STATE OF WASHINGTON
DEPARTMENT OF ECOLOGY

November 3, 2021

Re: SEPA Register 202105674, LP-21-00003

Thank you for the opportunity to comment during the Optional Determination of Non Significance process for the agricultural long plat application of 81 acres into 4 parcels and one open space, proposed by Mike and Debbie Stanavich. We have reviewed the documents and have the following comments.

**STANAVICH AG PLAT**

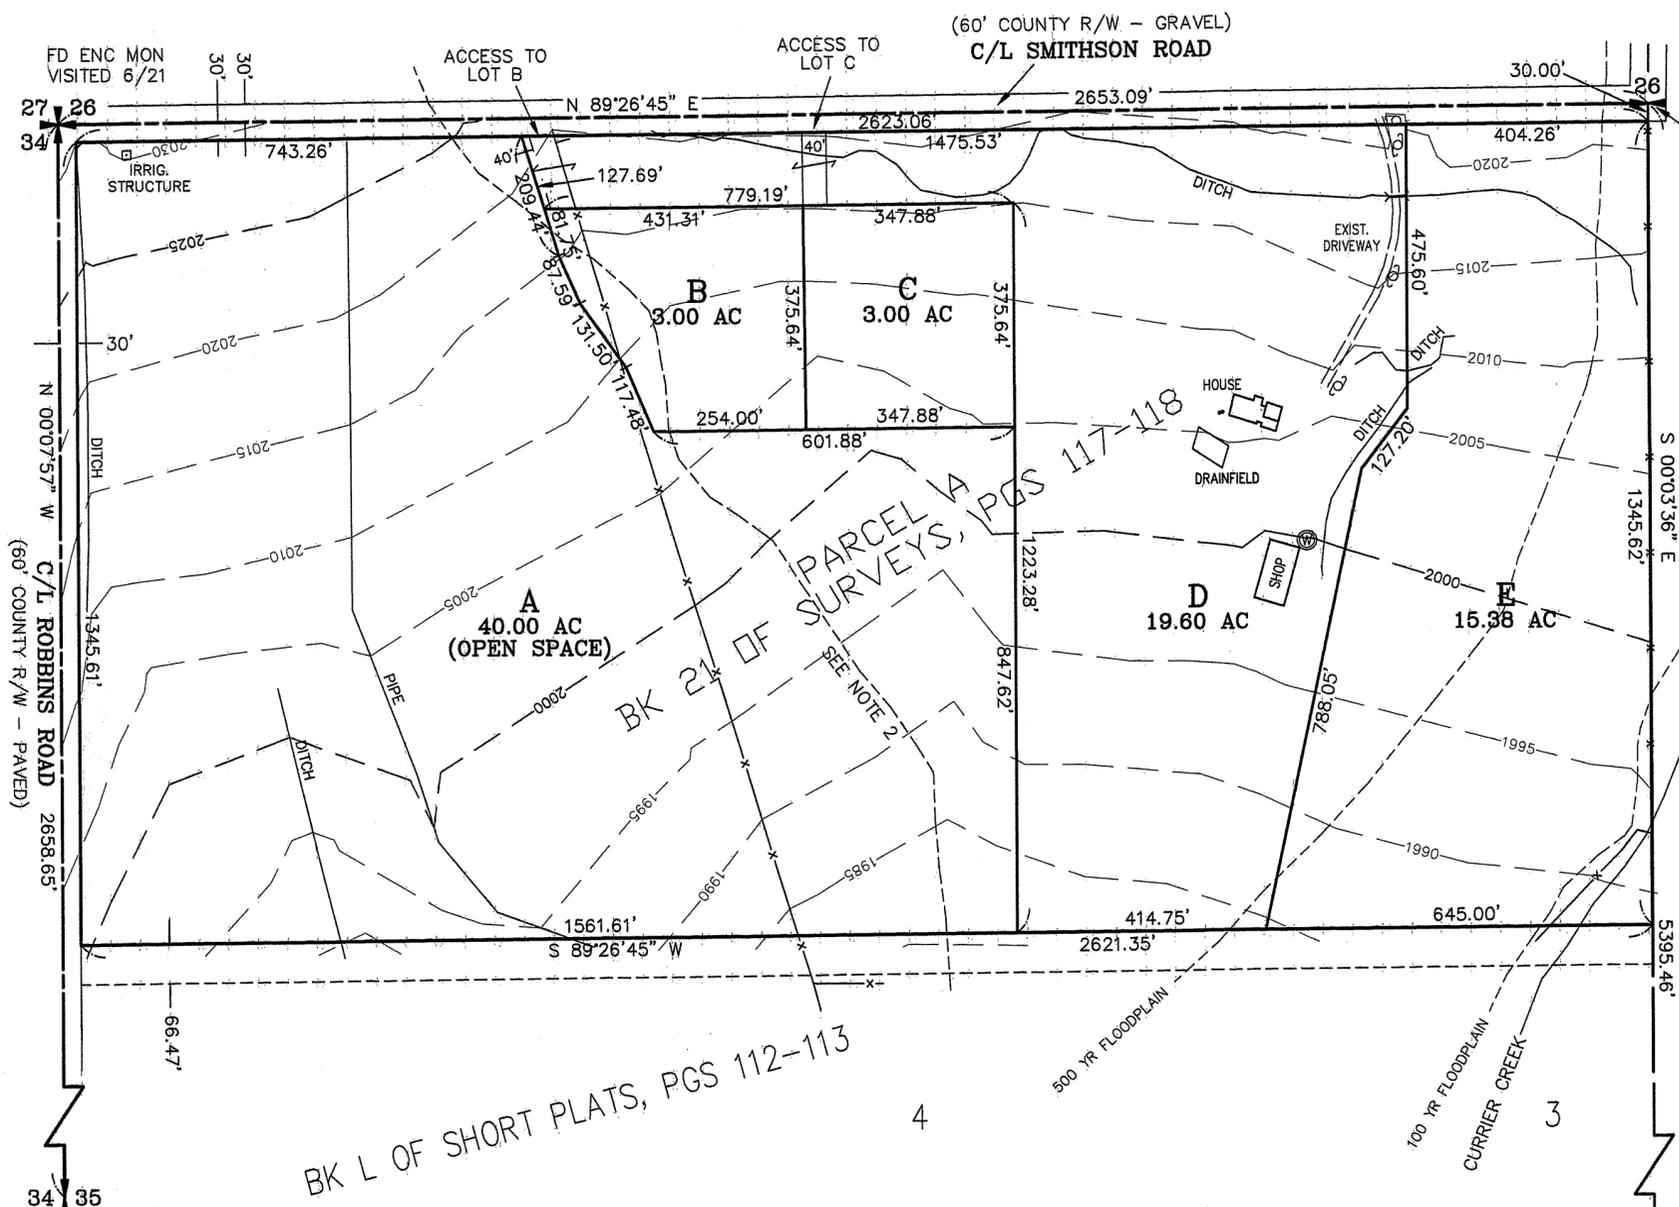
Ecology staff has conducted a desk review of the parcel. The review shows signs of hydrology occurring in the area during the growing season and especially during the dry months of the year (June-September). Image 1, is of the current National Wetland Inventory (NWI) data which is showing emergent wetland polygons occurring on the parcel.

The collective information suggests wetlands occur on the parcel. While the subdivision of the land itself will not generate impacts to the surrounding habitat, proposed development on the created parcels could impact potential wetland and buffer habitats.

Ecology recommends the County request a wetland delineation and rating be conducted prior to any development of the parcels. A delineation and rating are needed to determine the presence/absence of wetland habitat on the parcel and the extent of surrounding upland habitat landward of the wetland boundary required for upland buffer habitat, per the County's Critical Area Ordinance.
